**Application by National Highways for M3 Junction 9 Improvement Scheme**  
**The Examining Authority's 3<sup>rd</sup> written questions and requests for information (ExQ3)**  
**Issued on 6 October 2023**

**ExQ3: 6 October 2023****Responses due by Deadline 6: 27 October 2023**

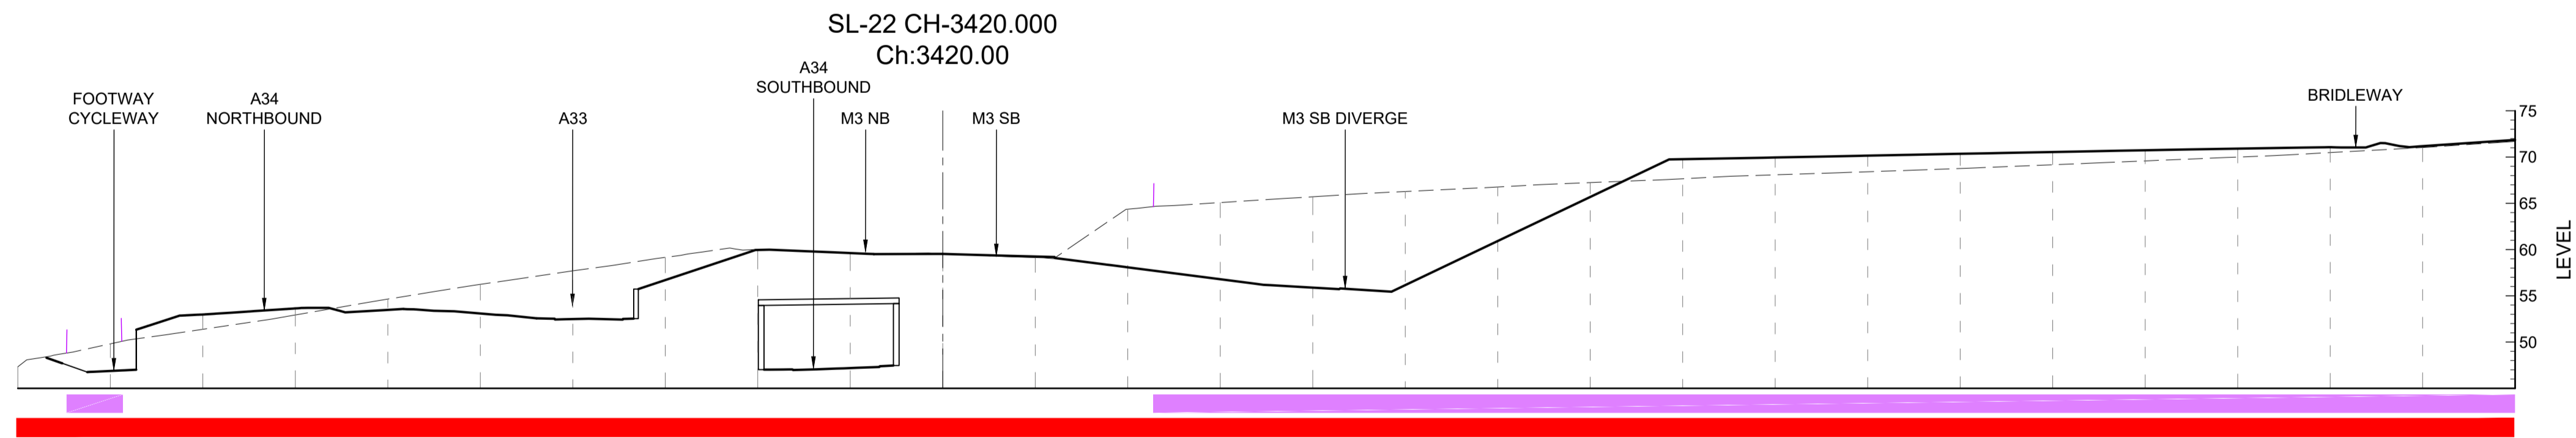
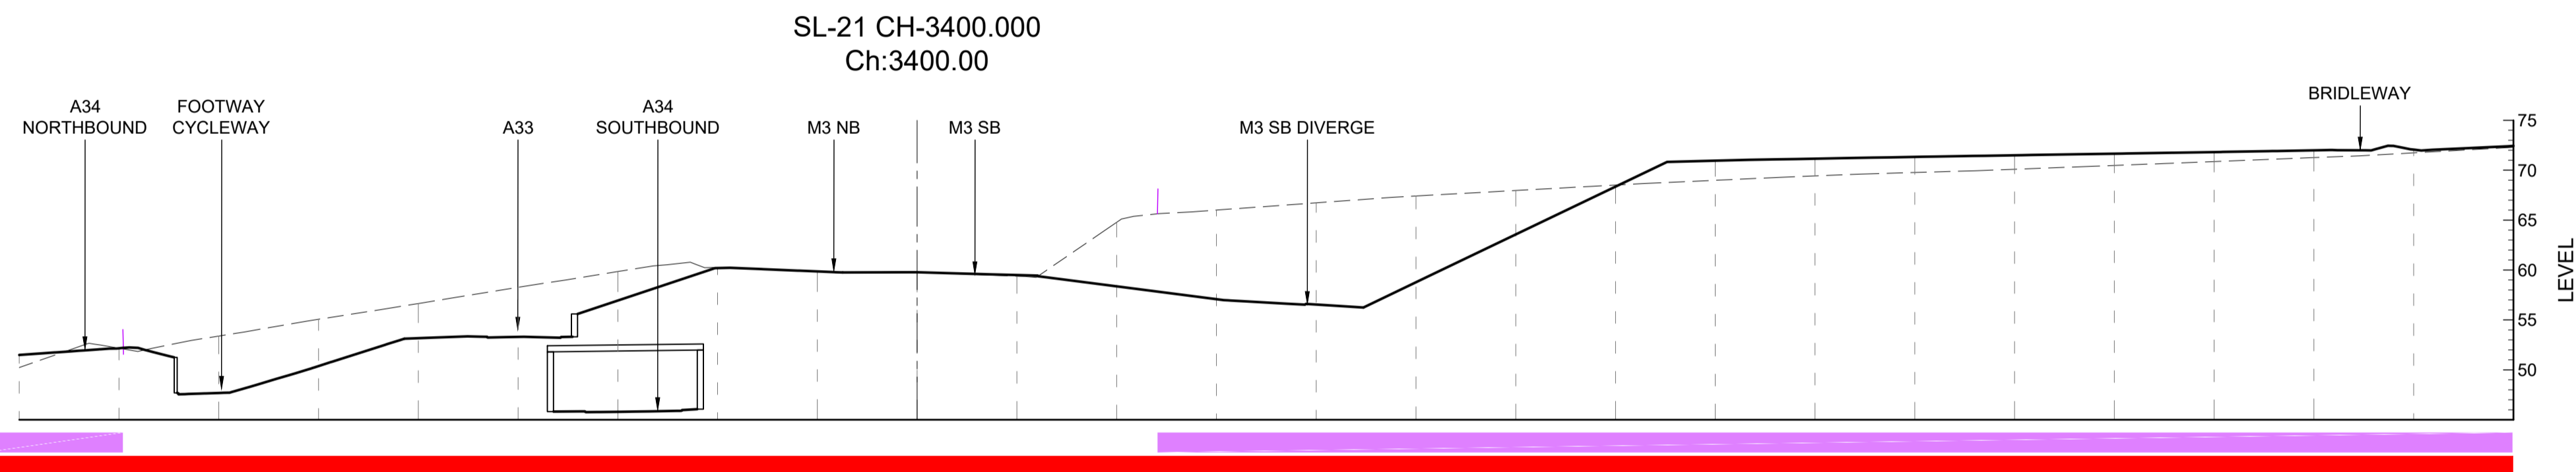
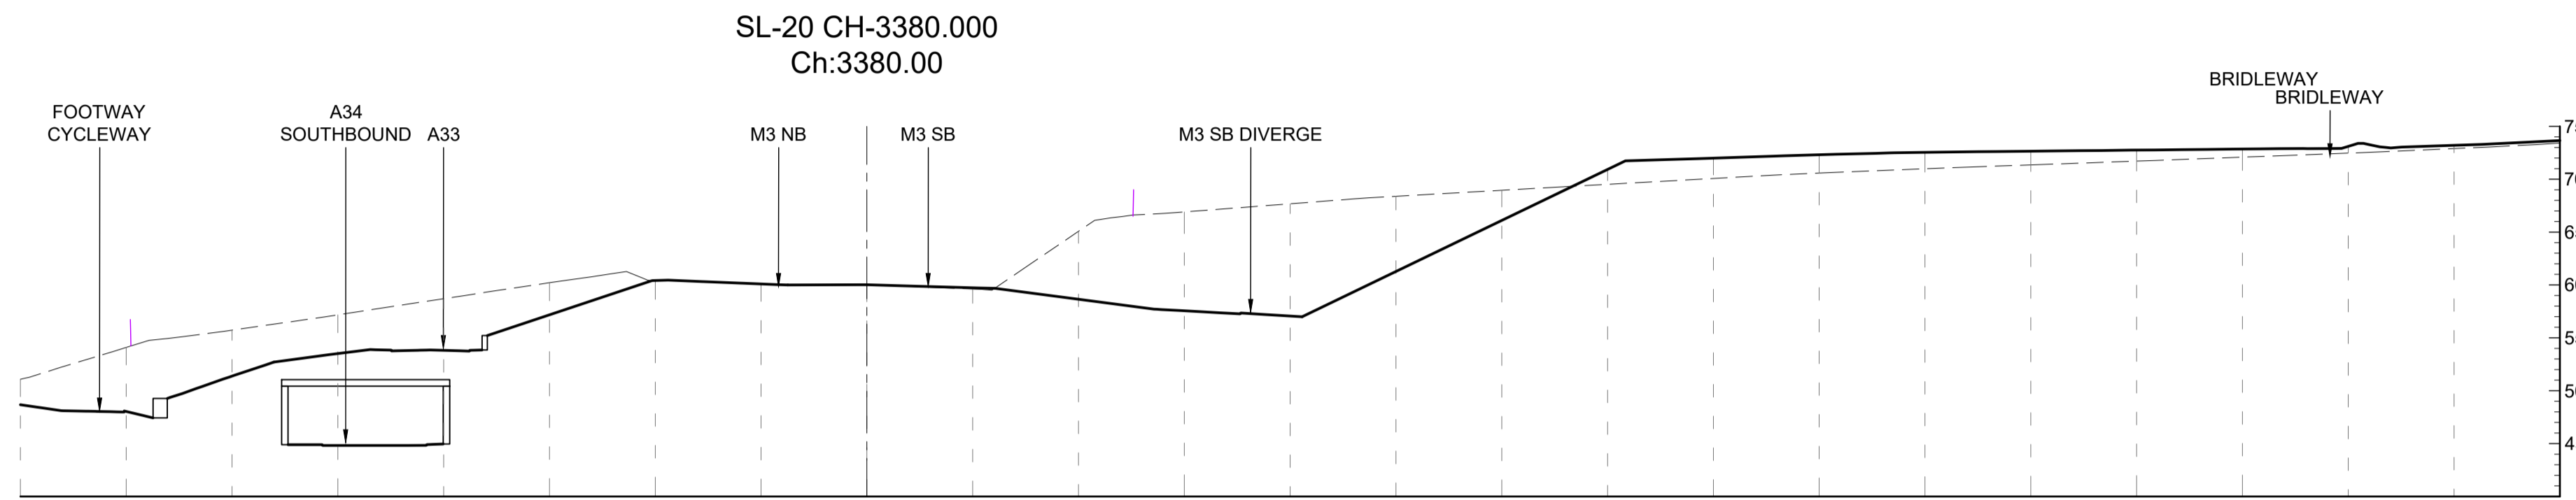
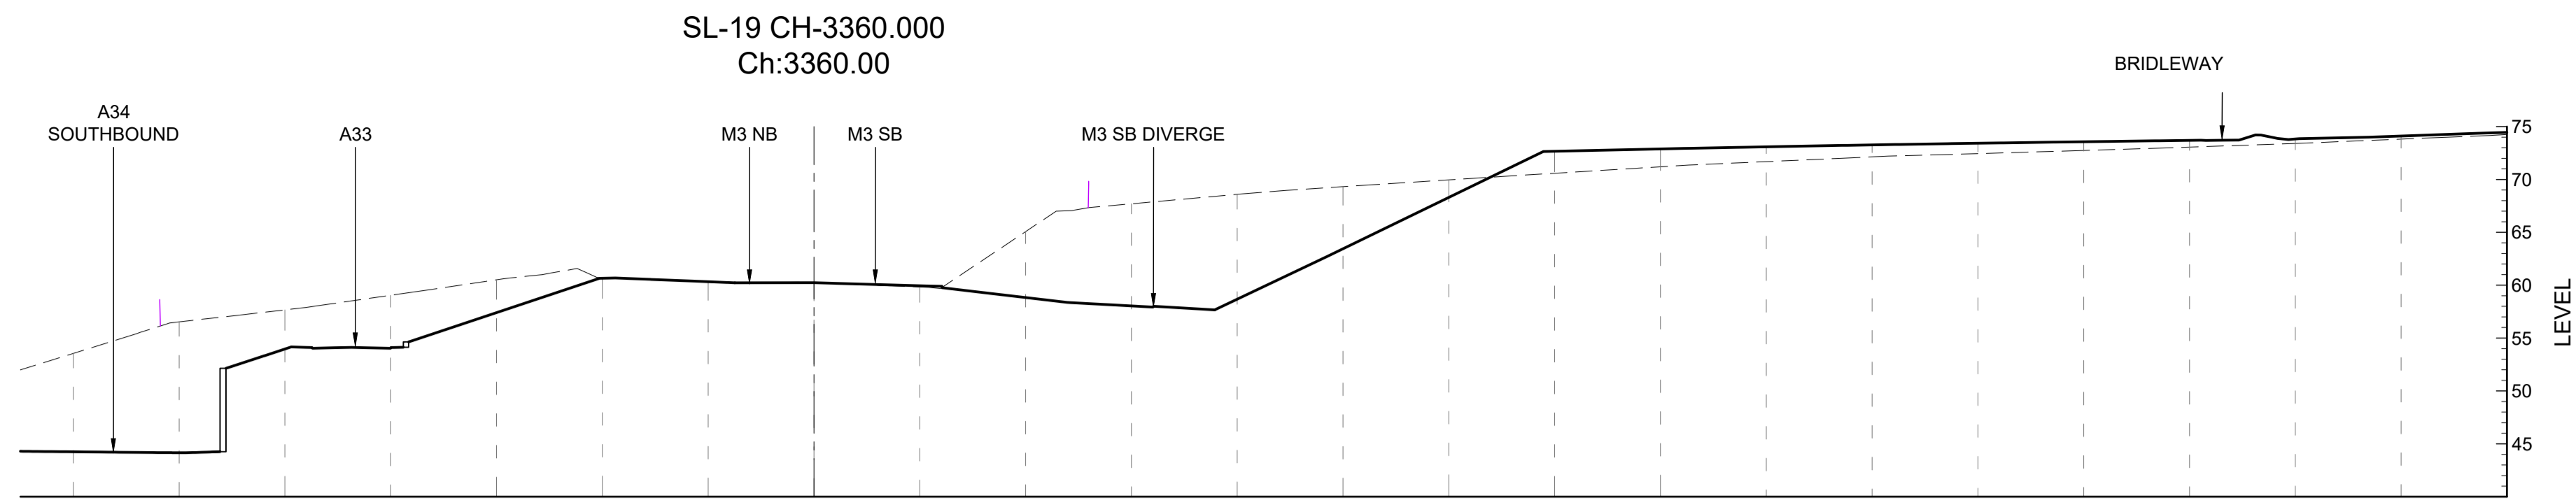
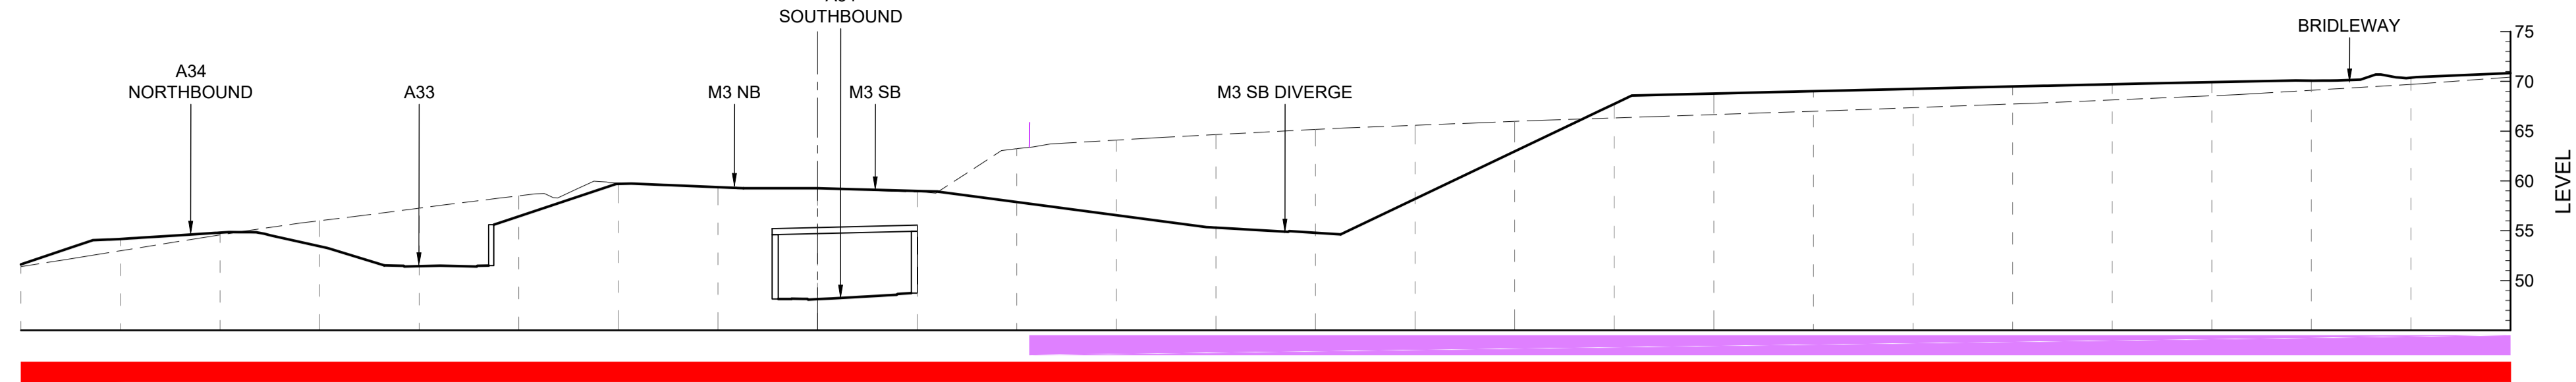
| <b>ExQ3</b>                                 | <b>Question to:</b>  | <b>Question:</b>   |
|---|--|--|
| Q1.3.1                                      | General<br><b>The Applicant</b>  | In ExQ 1.2.3 [PD-011] the ExA requested detailed engineering cross sections at 20m intervals along string CH-HML-E_M3SB between chainages 3000 and 4300. The cross sections were provided by the Applicant [REP5-003] however they omitted distance and level data as would be anticipated in detailed engineering sections. Please provide an update to the cross sections submitted at deadline 5 to include distance and level data in rows below the drawn sections. |
